Ribble Valley Borough Council  
Development Control

Application: 3/2020/0902  
Application 77 Salthill Road , Clitheroe  
Proposal: Erect 2 storey side extension

Existing Site Plan 1:500 @ A4

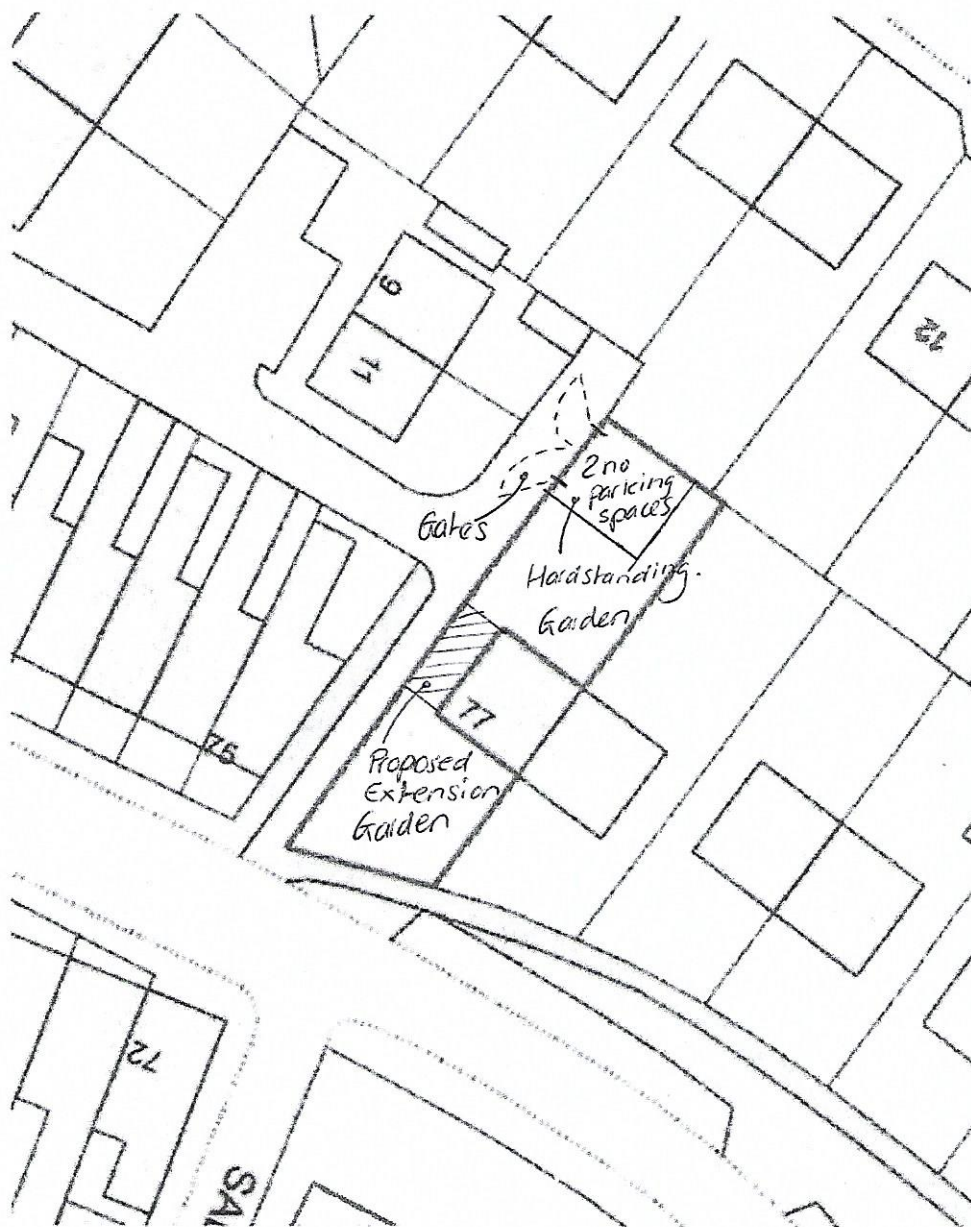
1 The submitted plan shows the rear parking area being gated with the gates opening out into the back street. This arrangement would not be considered acceptable. It is therefore suggested that the parking area either remains un-gated or the applicant considers the use of sliding gates.

2 It is generally considered necessary to allow a total length of 11 metres to access a parking space in this scenario, comprising of a 5 metre parking space and a 6 metre area to the rear for reversing / manoeuvring. Since the back street has a width of approximately 4m the length of the parking spaces should be increased to a minimum length of 7m and consideration given to widening the spaces to improve accessibility.
